WEST SUSSEX COUNTY COUNCIL CONSULTATION

TO:	Arun District Council FAO: Amy Myer
FROM:	WSCC - Highways Authority
DATE:	13 December 2021
LOCATION:	Former Westside Supplies Unit West of 17 to 18 Durban Road Bognor Regis PO22 9QT
SUBJECT:	BR/267/21/PL Development of a new build four storey block of flats for 24 units (13 No 1 bed and 11 No 2 bed). This application is in CIL Zone 4 (Zero Rated) as flats.
DATE OF SITE VISIT:	n/a
RECOMMENDATION:	No Objection
S106 CONTRIBUTION TOTAL:	n/a

GROUND FLOOR PLAN

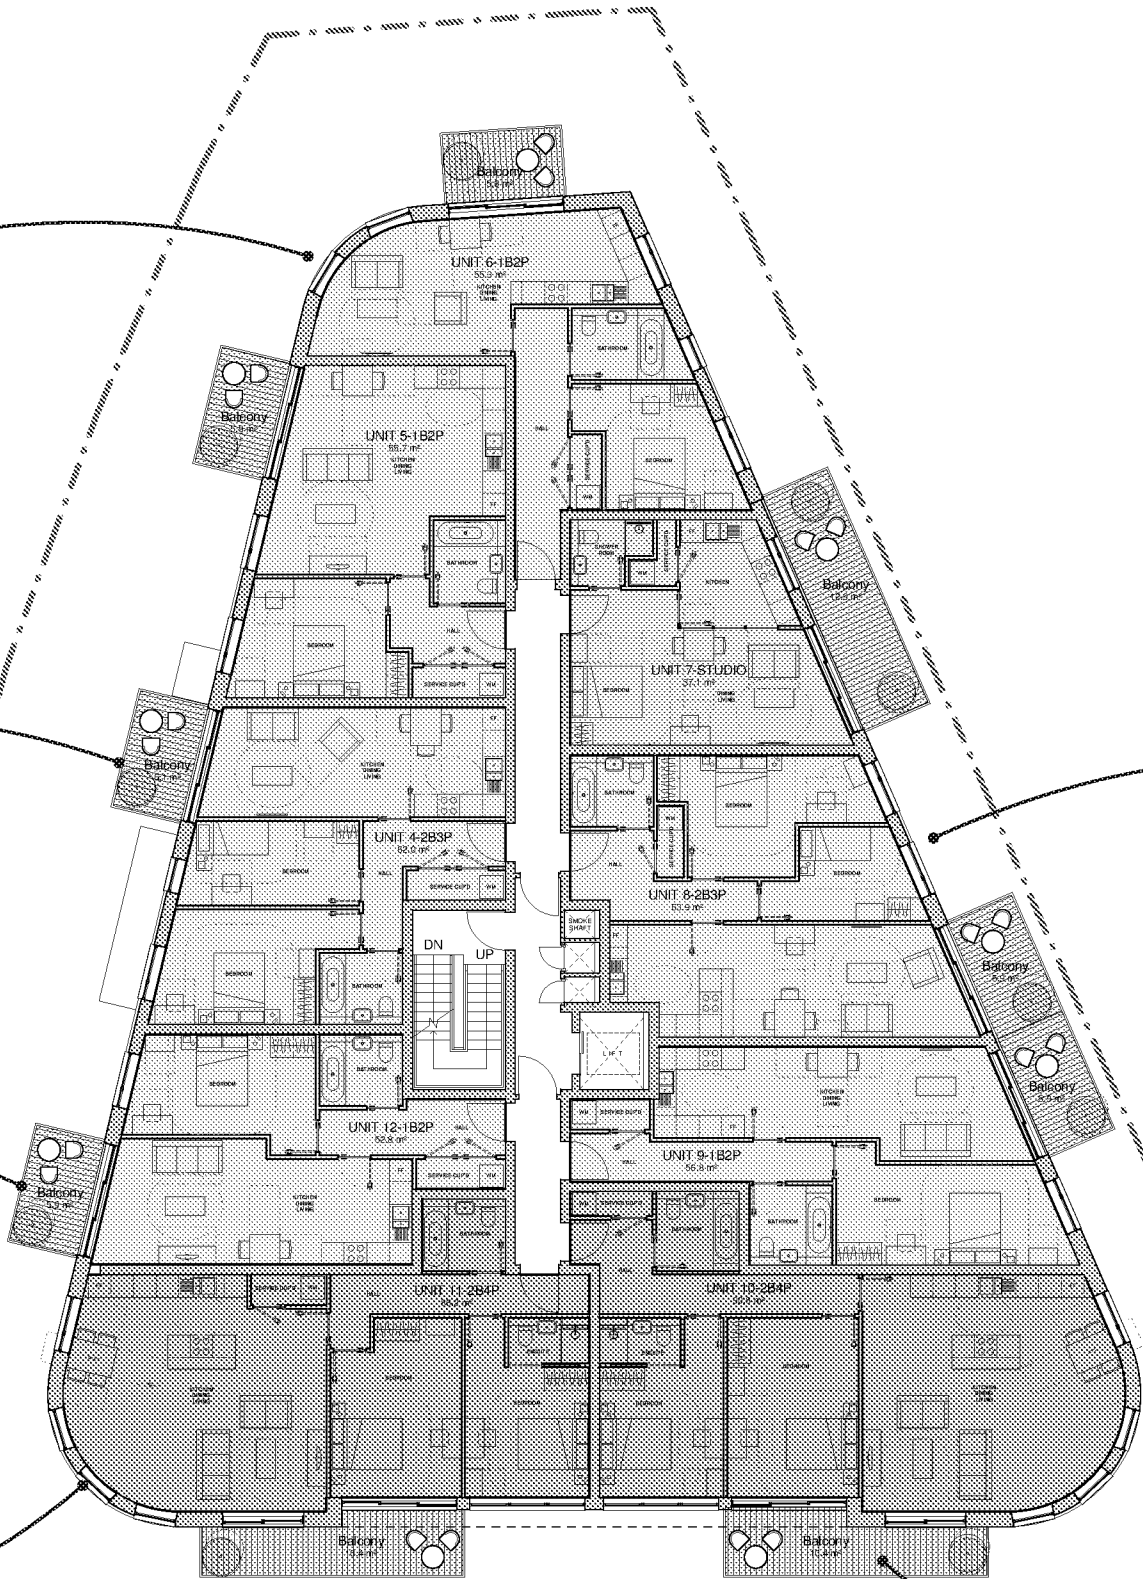
In line with Manual for Streets (MfS) parameters, for a posted speed of 30mph along Durban Road, visibility splay of 43m is achievable along the eastern direction, from a 2.4m back into the access. To the west 25m is achievable to the junction with Ash Grove. The setting back of the building will allow for the existing level of vehicular visibility upon exiting the junction to be maintained. This splay passes through applicant-maintained land and publically maintained highway and the LHA would therefore require that it is maintained in perpetuity via a suitably worded condition. The applicant should be aware that due to the proposed building position to the south of the site that the existing street name plate would require relocation. The applicant should enter into discussions with Arun District Council for this.

Considering the adjacent footway there would be a benefit to providing pedestrian visibility splays on either side of the access within the site by 2m x 2m. The boundary fencing within these splays should be kept to a height of 0.6m or below in order that emergency vehicles can account for pedestrians on the adjacent footway. Details of this can be secured by a condition.

WSCC's Guidance on Parking at New Developments (September 2020) has been used to calculate the car and cycle parking requirement for the proposed residential development. In line with these standards the development proposes a total of 26 vehicle parking spaces, 20 spaces within the undercroft and 6 spaces are provided at surface level, accessed directly from Durban Road. The 20 undercroft parking spaces will be provided with electric vehicle charging points which are in excess of the required 20% minimum provision of EV charging points. The LHA therefore consider that adequate level of parking provision is made for the development's needs.

A total of 24 cycle parking spaces is provided for the development within safe and secured bike store. The bike store is easily accessible from the pedestrian entrance from Ash Grove.

No part of the development shall be first occupied until a northern visibility splay of 2.4 metres by 43 metres has been provided at the junction of Durban Road and Ash Grove in accordance with the approved planning drawings. Once provided the splays shall thereafter be maintained and kept free of all obstructions over a height of 0.6 metre above adjoining carriageway level or as otherwise agreed.

No part of the development shall be first occupied until pedestrian visibility splays of 2 metres by 2 metres have been provided either side of the site vehicular access onto Durban Road in accordance with plans and details submitted to and approved in writing by the Local Planning Authority. These visibility splays shall thereafter be kept free of all obstructions over a height of 0.6 metre above adjoining carriageway level or as otherwise agreed.

No part of the development shall be first occupied until the vehicle parking and turning spaces have been constructed in accordance with the approved plan. These spaces shall thereafter be retained for their designated use.

No part of the development shall be first occupied until covered and secure cycle parking spaces have been provided in accordance with plans and details submitted to and approved by the LPA.
